Re: Kurnell Terminal SSD-5544 MOD 7

**Consider drafting condition of consent based on following recommendations from report Kurnell Terminal - FIRE SAFETY STUDY ADDENDUM.**

Michele Stromquist  
A/Manager,  
Major Hazard Facilities

**FIGURE F3:
FIRE WATER SYSTEM AND
OILY WATER SEWER**

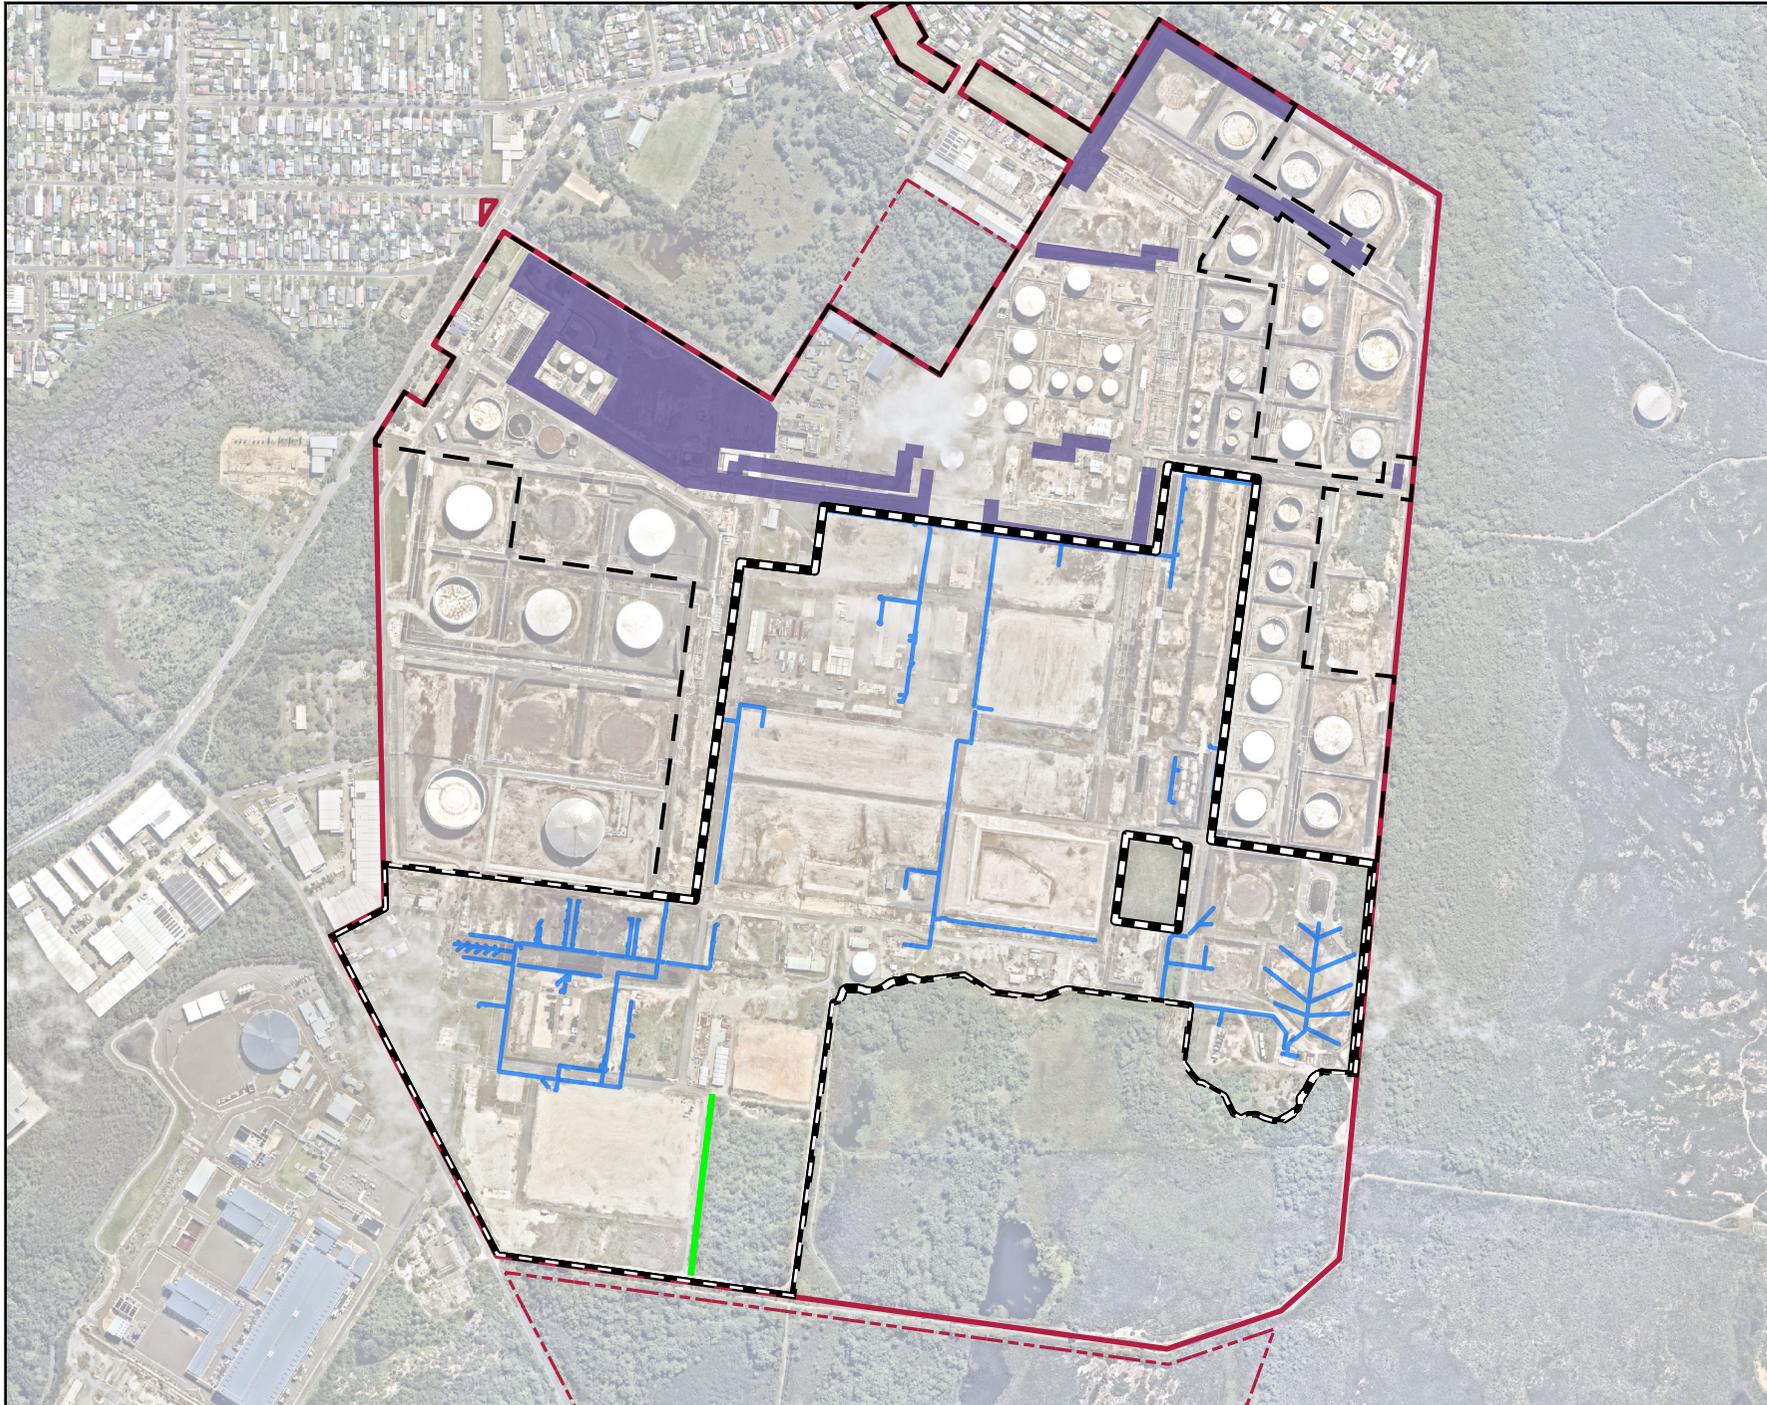
Implement deluge sprinklers system to protect firewater pumps.

3. *Consider the implementation of OE Guidance Document requirements for firewater pumps (e.g. the provision of deluge sprinklers to protect firewater pumps) as part of the Relocated Pumphouse detailed design. This requirement is specified in the OE Guidance Document and is not an explicit requirement from the Australian Standards.*

As part of detailed design for firewater system, modify existing firewater system (i.e. additional lines and/or upsize lines) to enable the required hydraulic performance.

5. *Ensure that as part of the detailed design for the firewater system, modifications be implemented to the existing firewater system (i.e. additional lines and/or upsized lines) to enable the required hydraulic performance to be delivered.*
